WEST SUSSEX COUNTY COUNCIL CONSULTATION

TO:	Arun District Council FAO:Michael Eastham
FROM:	WSSC - Public rights of Way
DATE:	2 March 2020
LOCATION:	Land off Arundel Road Angmering BN16 4ET
SUBJECT:	A/122/19/OUT Outline application with some matters reserved for the erection of up to 160 dwellings with public open space, landscaping and sustainable drainage systems (SuDs), vehicular access point from Arundel Road together with up to 557 square metres of B1/B2 units with associated parking provision & vehicular access point from Arundel Road & land made available for expansion of current sports pitch provision to form a sports-hub (following the demolition of existing commercial units and one bungalow) (resubmission following A/36/18//OUT). This application is a Departure from the Development Plan. An amendment received.
DATE OF SITE VISIT:	n/a
RECOMMENDATION:	Advice
S106 CONTRIBUTION TOTAL:

Figure 5.1: Development Framework Plan.

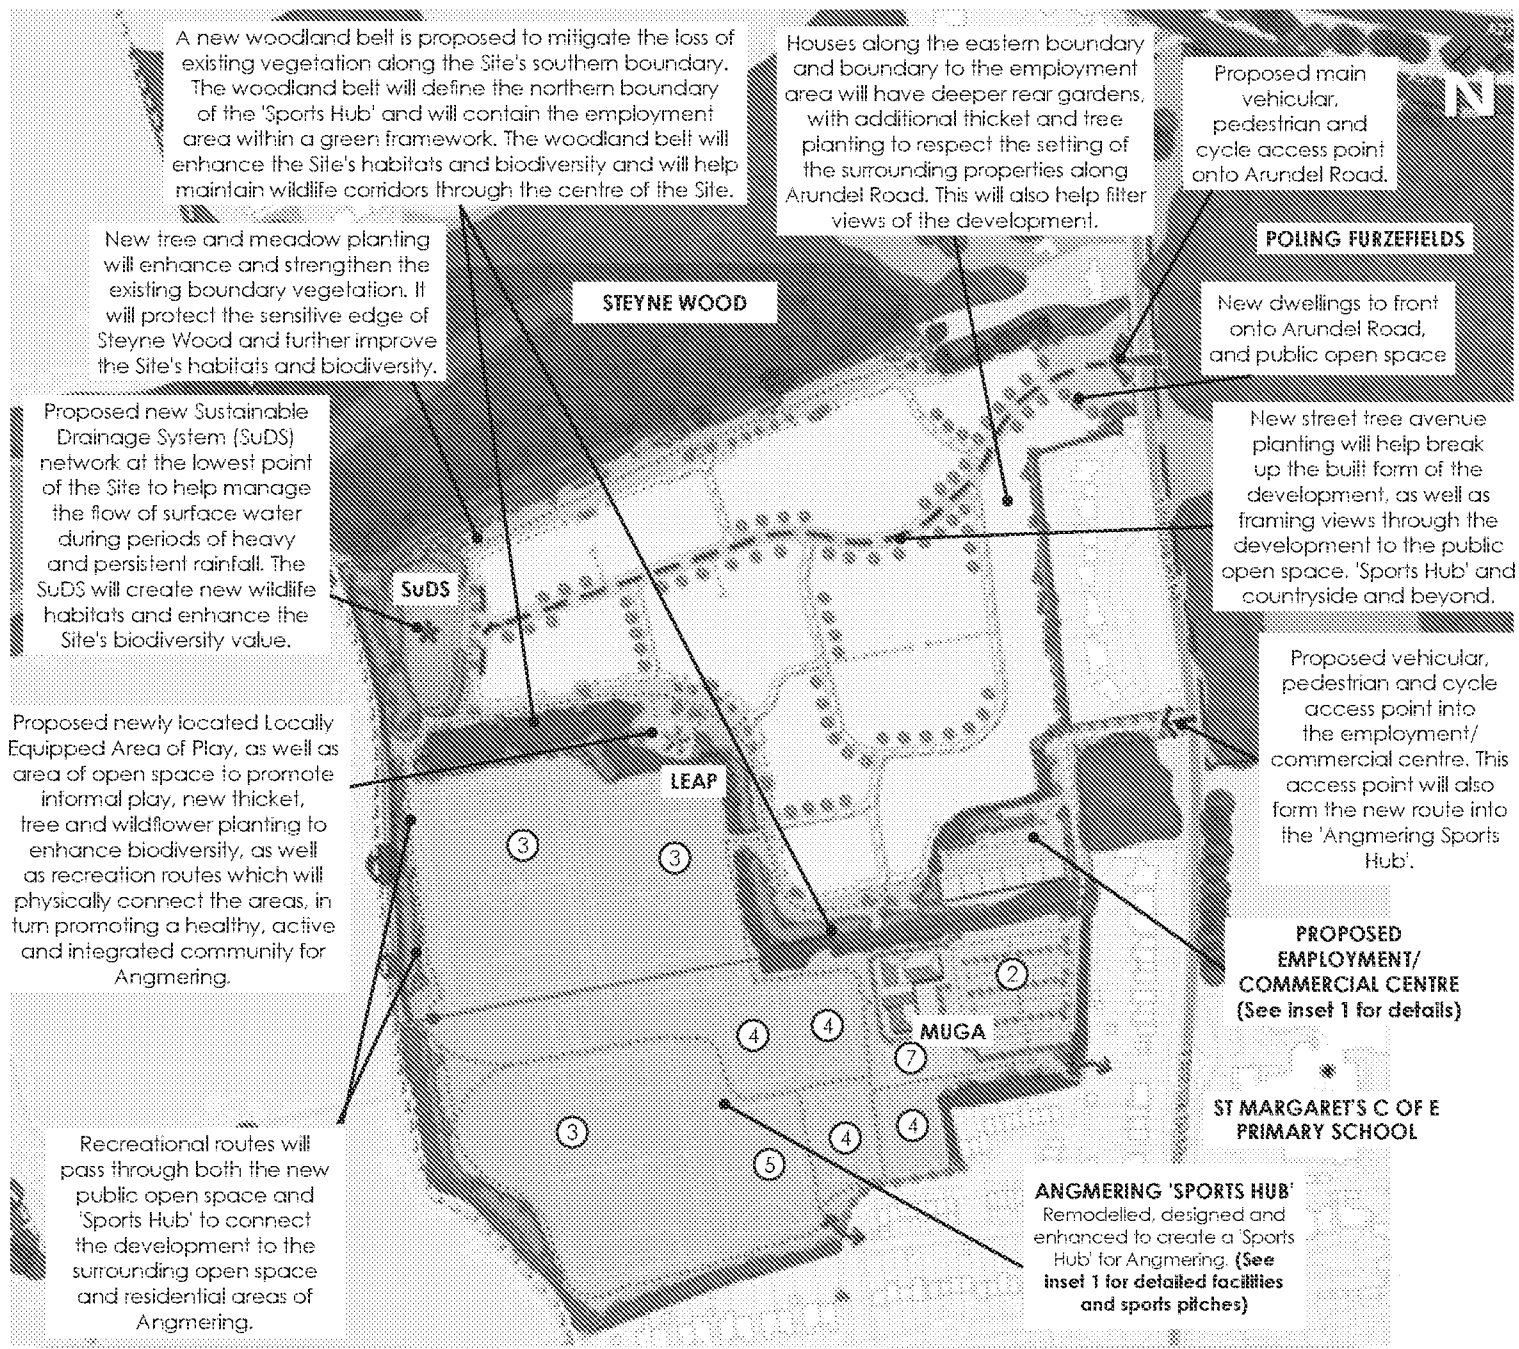
Public Rights of Way (PROW) would welcome the opportunity for a creation of a bridleway/cycle path linking the A27 to Angmering. However, in its current state the condition of FP2176 is not suitable to be a bridleway/cycle path as sections of the route are narrow, fenced in and unsurfaced.

The narrow width at the southern end of FP2176 means that it is not suitable as a bridleway/cycle way and it is uncertain how an upgrade here could be achieved within its current boundaries.

Notwithstanding these limitations it is conceivable that the developer could negotiate with the landowners, maybe purchasing the necessary land and dedicating bridleway/highway rights, to enable a 3m wide surfaced bridleway/cycle route to be created.
